Arun District Council
Arun Civic Centre
Maltravers Road
Littlehampton
West Sussex BN17 5LF
Planning & Building Control General Enquiries
Tel: (01903) 737756 Fax: (01903) 730442
Dx: 57406 Littlehampton
Minicom: 01903 732765
e-mail: planning@arun.gov.uk
website: www.arun.gov.uk/planning

Application No: AW/136/22/HH
Site Address: 8 St Richards Drive Aldwick PO21 3BH
Description of works: Erection of two storey side extension, single storey rear extension, first floor front extension with juliet balcony, installation of front porch, increase main roof ridge height, new pitched roof over existing dormer and alterations to fenestration/openings.

Thank you for your internet representation made on 30th June 2022 which has been recorded as an objection with the comments as follows:

North (front) elevation | proposed

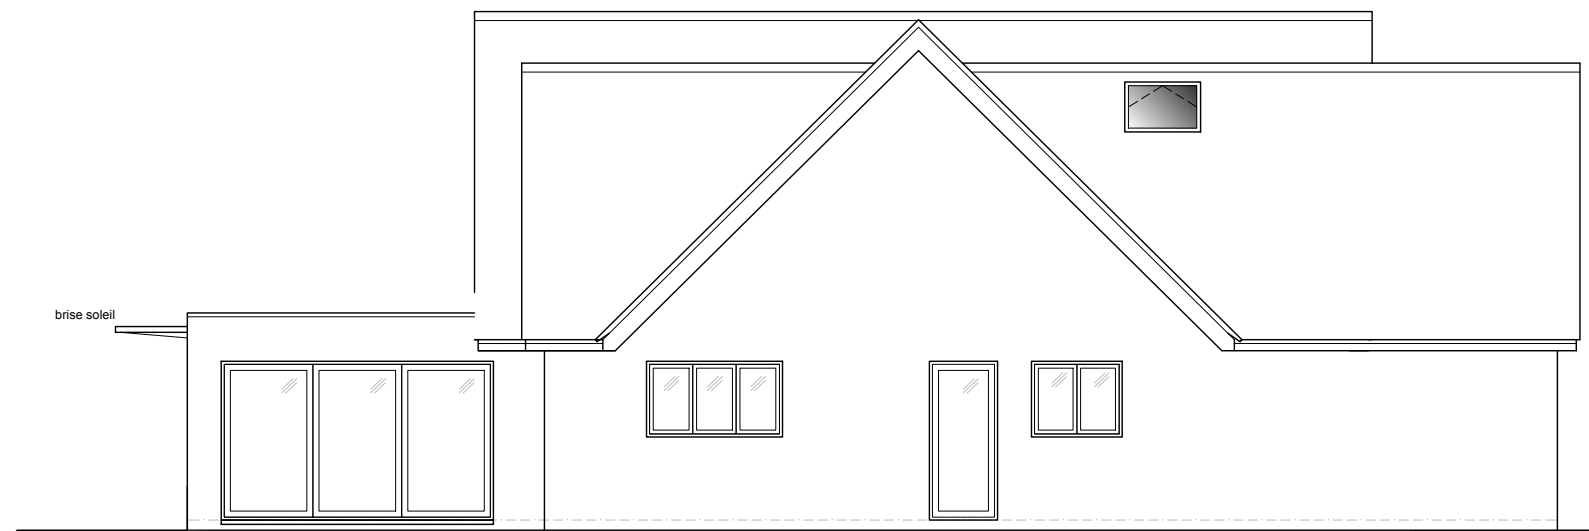
With reference to the Arun Local Plan 2011-2031 (2018) I believe the plans submitted do not adhere to policy D DM4. The proposed extension will effectively double the front elevation which means that the extension is not visually subservient to the existing structure (point (b)). The proposed two-storey side extension will have an adverse overbearing effect on the neighbouring property, 10, St Richard's Drive as it will extend to within 1m of the boundary between the properties. The additional shadow cast by the higher roof will have an adverse impact on the light to the study and WC and, potentially, to the light in the living room, as the plans extend beyond the back exterior wall of number 10. The garden, and specifically the patio area will suffer from overshadowing. With reference to point (e) of the policy, the established spatial character of the street is based on there being a good amount of space between each property. The proposed plans will compromise this characteristic, as the side extension is overly large for the street scene. Whilst the properties on the street are of varying designs, what unites them is that they sit in generous plots and none of them fill or dominate their plots in the way that the proposals for this property would, given the sheer width of the frontage to the street and its scale and massing.

The scale of the proposals is such that the extension is equally dominant, not subservient to the existing property.

The document goes on to say that "side extensions should in most cases be set back from the front of the house in order to play a subservient role to the original building... Extensions should also in most cases be set down from the existing roof ridge height by a minimum of 0.5 metres,". The side extension proposal in this case is set in front of house to incorporate the existing garage, and the roof ridge across the whole property is proposed to be raised.

Looking again at the proposed front elevation, the first floor will be less than 1m from the boundary, which does not adhere to the Arun design guidelines which state "In streets characterised by small gaps between buildings, extensions must not close important gaps in the street scene by leading to a terracing effect, or remove existing external access from front to back gardens. This can generally be ensured by keeping extensions at least 1 metre away from the side boundary of a plot at ground floor and 2 metres away at first floor and above". The plans will also contravene the next principle "No part of the development should generally protrude further than the 70 degree line taken from the plot boundary" as the proposals extend to a line of around 84 degrees from the plot boundary.
